CITY OF ALBUQUERQUE

November 17, 2020

**Re: Sandia Lab FCU
1100 Rio Grande Blvd NW
Traffic Circulation Layout
Engineer's 11-12-2020 (H13-D109)**

Based upon the information provided in your submittal received 11-11-2020, the above referenced plan cannot be approved for Building Permit until the following comments are addressed:

ENGINEER'S SEAL RONALD R. BOHANNAN P.E. #7868	SANDIA LAB FCU RIO GRANDE + 1-40	DRAWN BY RG
	TRAFFIC CIRCULATION LAYOUT	DATE 10-8-2020
	TERRA WEST, LLC 5571 MIDWAY PARK PL NE ALBUQUERQUE, NEW MEXICO 87109 (505) 858-3100 www.tierrawestllc.com	DRAWING 2012100-SP
		SHEET # C1
		JOB # 2012100

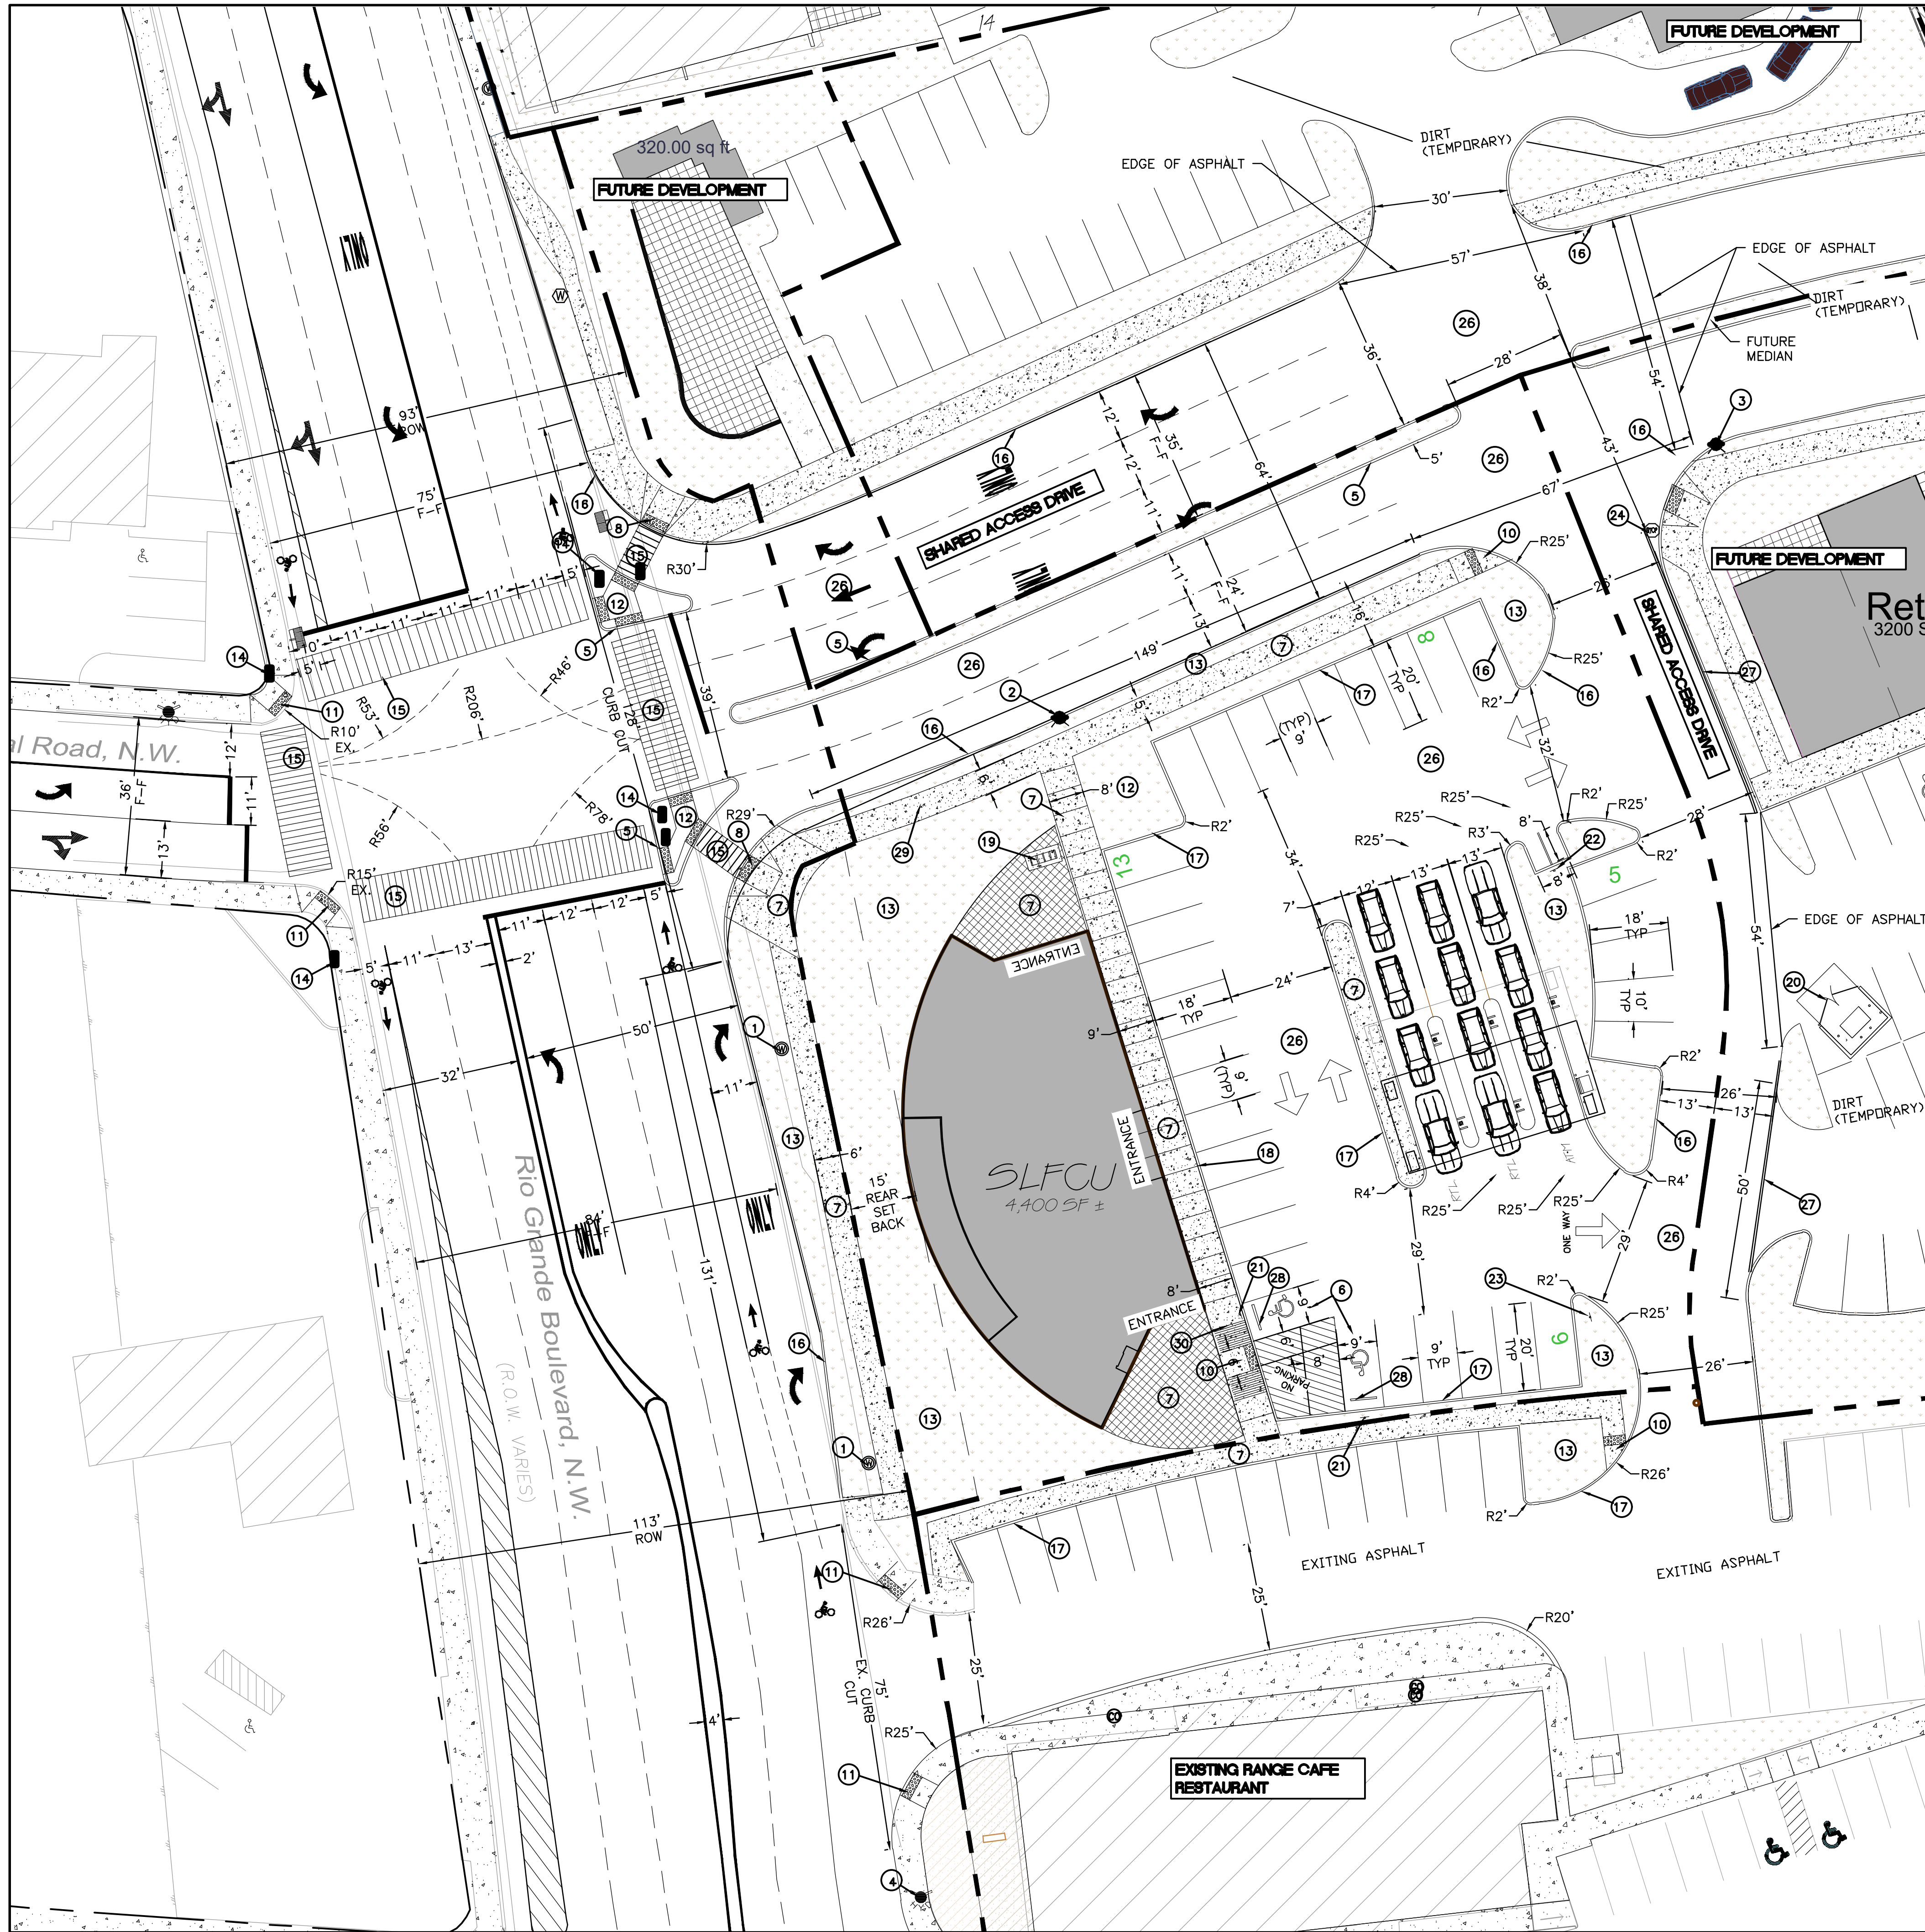
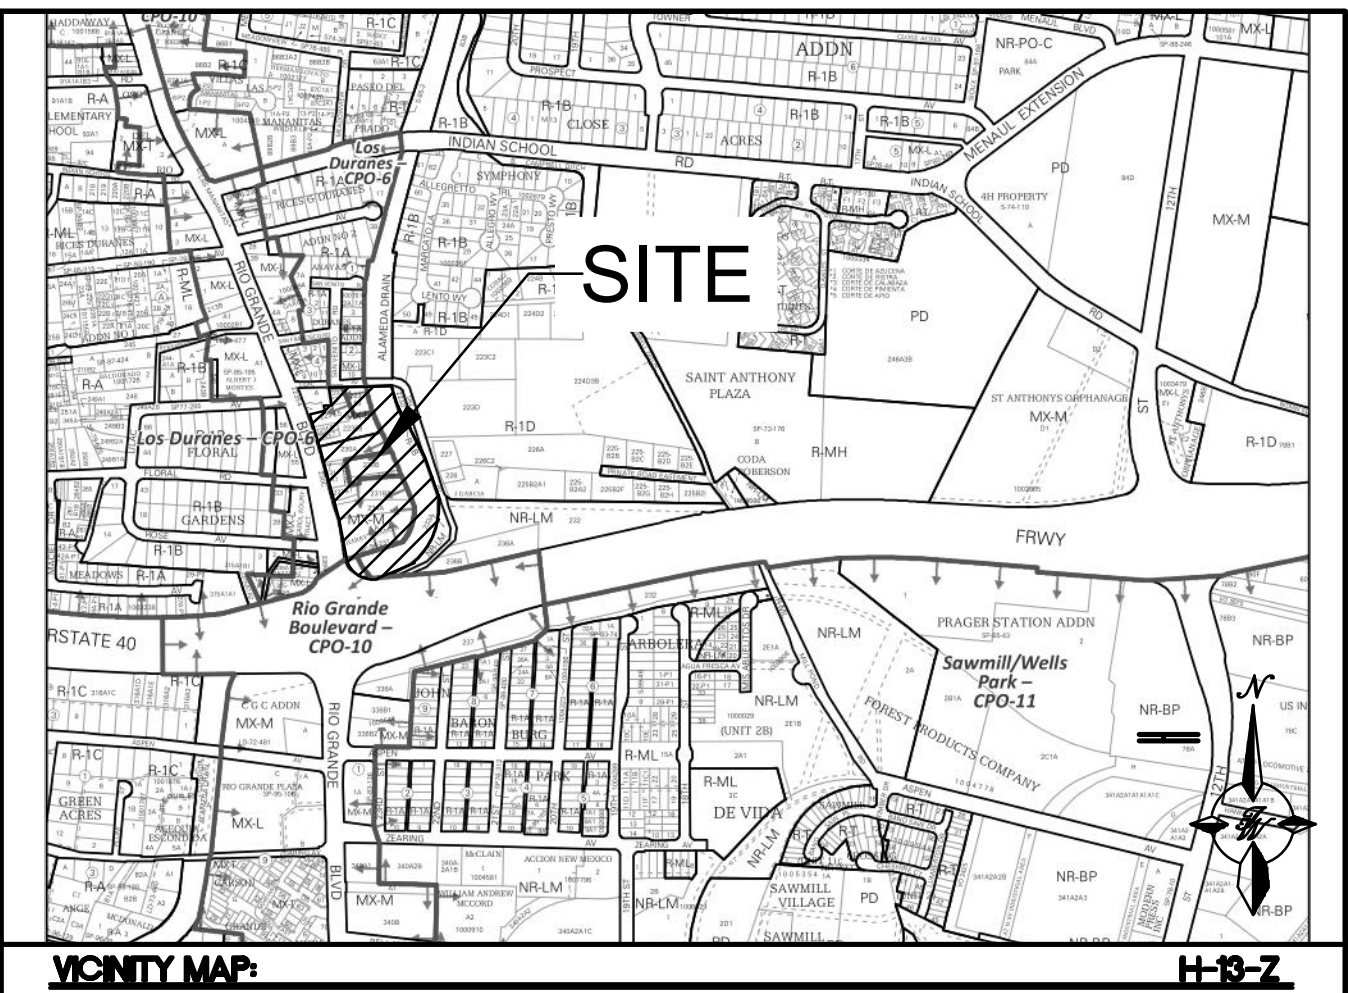
1. ADA curb ramps must be updated to current standards and have truncated domes(add to keyed note 7) installed.
2. Motorcycle parking spaces: Label pavement MC.

3. All one-way drives shall have "One Way" and "Do Not Enter" **signage and pavement markings**. Provide **details of posted signs and striping**.
4. Provide a way arrows for the proposed drive thru lanes on orientation.

8. Keyed Note 20(both sides) and Do Not Enter(pavement markings) will need to be provided at exit onto shared access road.
9. You will need to coordinate with Traffic Operations on the existing signal to assure that the correct phasing and cycle length are appropriate for the proposed development.

10. You are proposing a temporary asphalt curbing onto the proposed site development Why? And need to provide detail on how you will connect a std

c&g to asphalt curbing. You will need to provide concrete (std c&g) at the proposed curb return to your site development lot.

11. Entrance access: Is 12 ft adequate enough to handle any delivery/Refuge vehicles entering and existing for its temporary condition? Verify.
12. Construction removal/build notes are in conflict with keyed note 16 at Rio Grande frontage.

13. Keyed Note 6: Call out sidewalk per COS std dwg 2430 instead of concrete pavement.
14. Keyed Note 8: COA std dwg 2443 is referenc, but there is no such number. Please provide separate detail.

15. Keyed Note 12: References 2415C, there is no such number. Clarify.
16. You are referencing COA std dwg 2600 (NM DOT) please provide all these details.

17. Proposed keyed note 7 needs to connect to proposed keyed note 6 and add truncated dome verbiage to the note 7.
18. Since you are building to the southern property, then the corner ramp will need to be replaced and a detail provide on how you will connect/tie-in new concrete onto existing ramp without interfering with ADA slopes.

19. Proposed median entrance: Why have you set the median nose back and proposed striping at entrance?
20. Make sure keyed note 11 matches up with existing striping at intersection and contact Traffic Operations to make sure this is what is the intention of crosswalk striping.

23. ADA ramp opening will be blocked by parking stall on the south portion of parkings stall. Clear up this concern.
24. Main entrance: Are you proposing a 6 ft valley gutter? If so, please annotated that the invert should be 1 inches instead of 1.5 inch.
